DECISION DELEGATED TO HEAD OF PLANNING

Application No: H02-0817-25 **Applicant:** G Khan

Proposal: Change of use of part of land from former bus/coach yard to vehicle storage (Sui Generis) for up to 50 cars - Retrospective

Location: Alderlands James Road Crowland

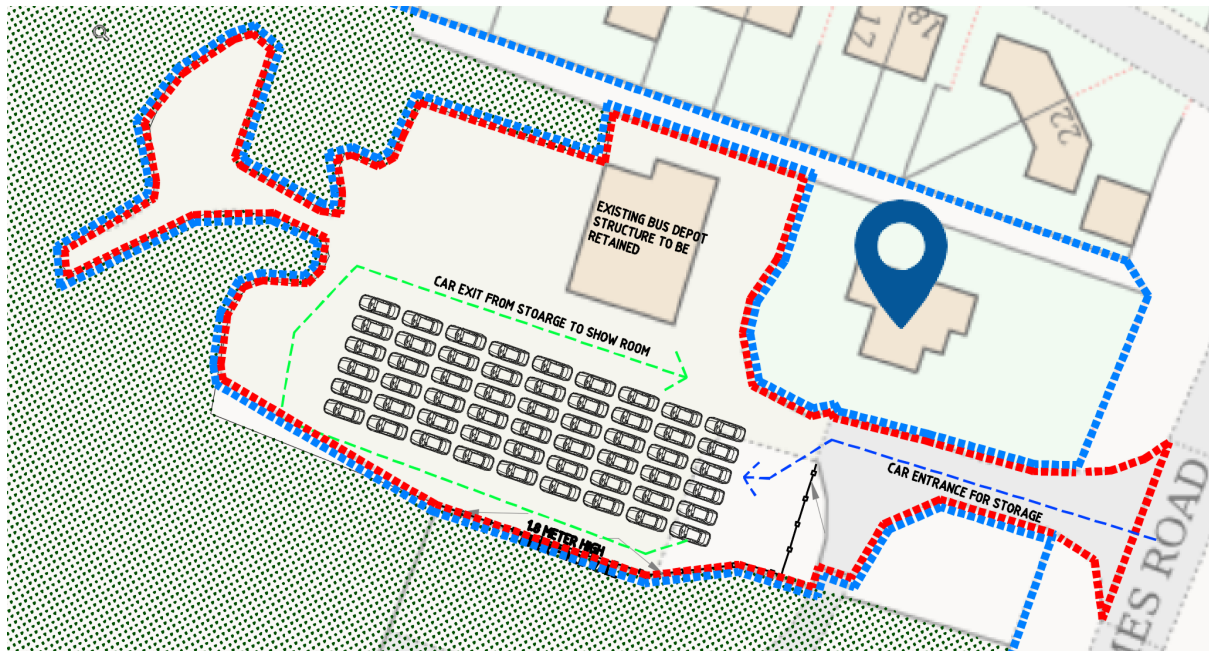
It says that the number of cars to be stored will be capped at 50 but the site plan details 54 cars. The Design and Access statement refers to 5 rows of cars with 6m-6.5m aisles for manoeuvring but this is not detailed on the site plan. Reference is made to a small number of spaces for staff and management and turning for a car transporter - this is not detailed on the site plan.

Lincolnshire County Council, as Local Highway Authority, have been consulted and have stated that "It says that the number of cars to be stored will be capped at 50 but the site plan details 54 cars. The Design and Access statement refers to 5 rows of cars with 6m-6.5m aisles for manoeuvring but this is not detailed on the site plan. Reference is made to a small number of spaces for staff and management and turning for a car transporter - this is not detailed on the site plan."

Notwithstanding this request for additional information, it is acknowledged that the applicant proposes no changes to the existing access/egress arrangement on James Road and there there is ample space for manoeuvrability within the site. Highways requirements, whilst not ideal, could be overcome through the requirement for a more detailed site plan, showing manoeuvrability within the site as well as staff parking spaces. It is considered that these elements can be conditioned given the concerns do not relate to unacceptable highway safety or residual cumulative impacts.
